**Our Case Number: ABP-316828-23**

**Re:** Tallaght/Clondalkin to City Centre BusConnect Core Bus Corridor Scheme.  
Tallaght/Clondalkin to Dublin City.

# South Dublin County Council Submission on Bus Connects

Tallaght/Clondalkin to City Centre Core Bus  
Corridor Scheme.

Sheet Number: 1 of 1

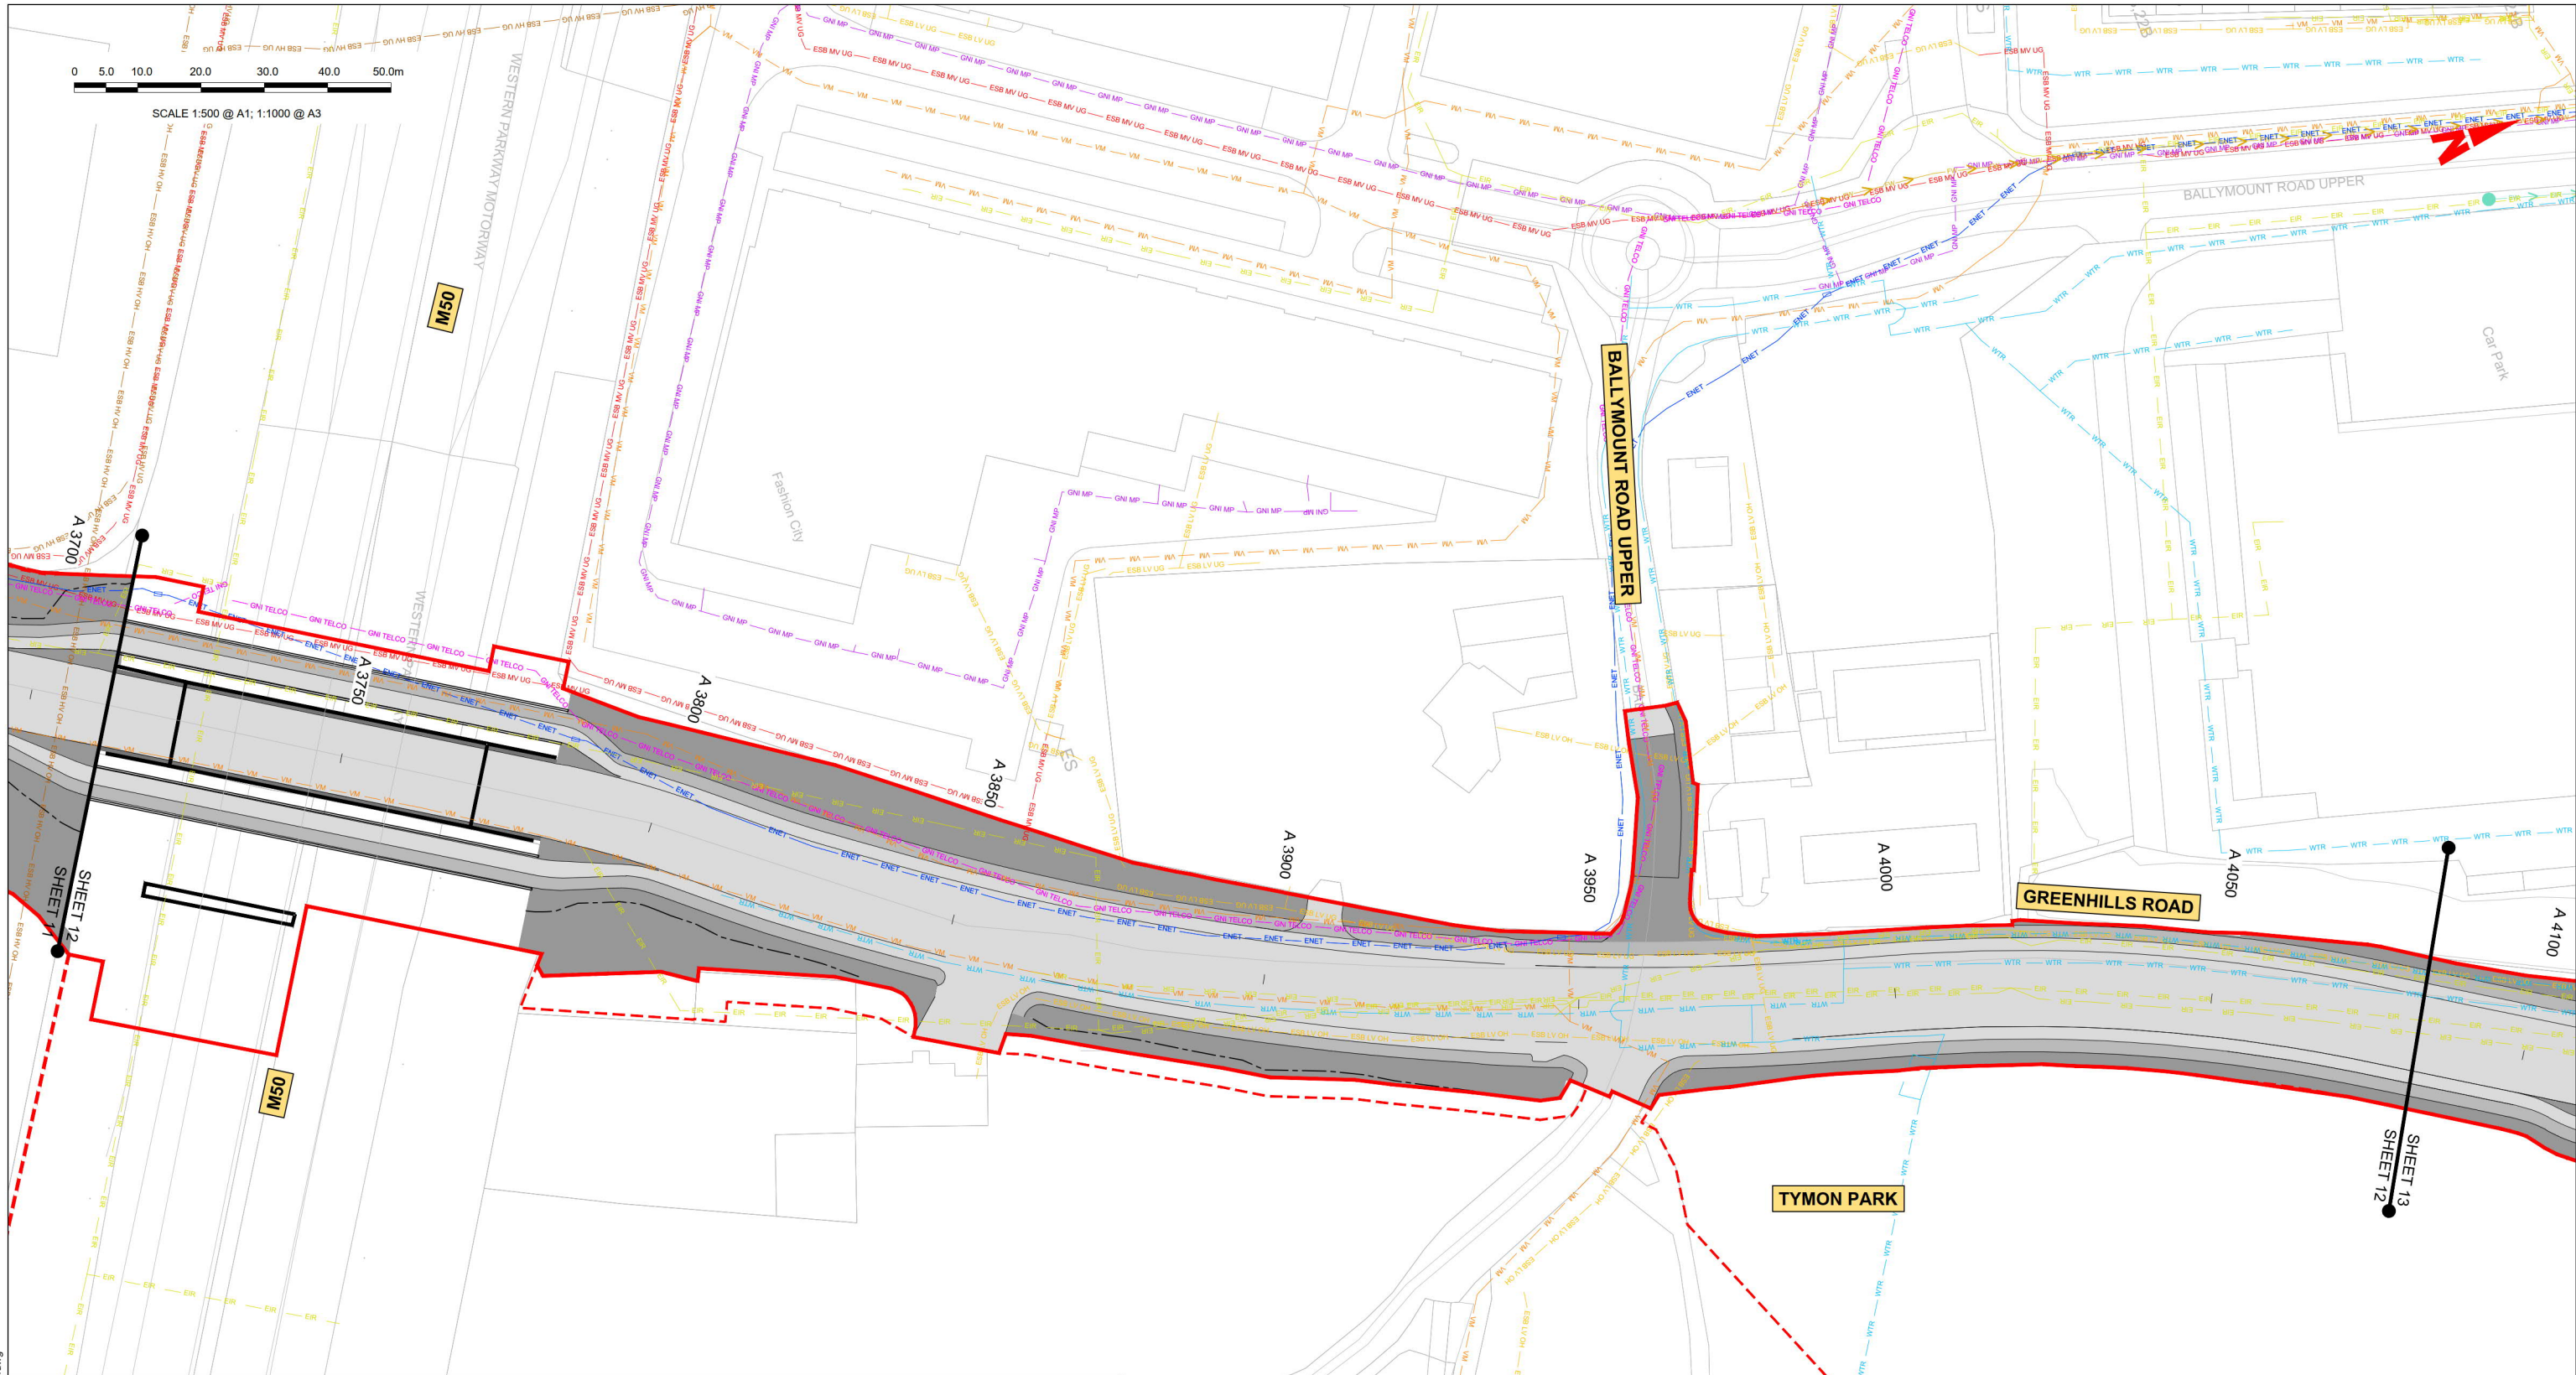
- b. The proposed cycle bridge and ramp. appears of standard engineering specification, and an uplift in design quality and appearance is warranted in this important location at a key entry in the wider City Edge regeneration lands, including for example

- The ramps and crossings need to be a minimum of 10m wide to attract users providing for a min of 3m ped and 2m cycle lanes in both directions.
    - The landing/arrival spaces need to be sufficiently sized, open and well designed incorporating planting and signage

- The railings and surface treatments needs to be of the highest quality, robust and durable
    - It needs to be well lit.
    - Clear and well considered wayfinding and sign posting
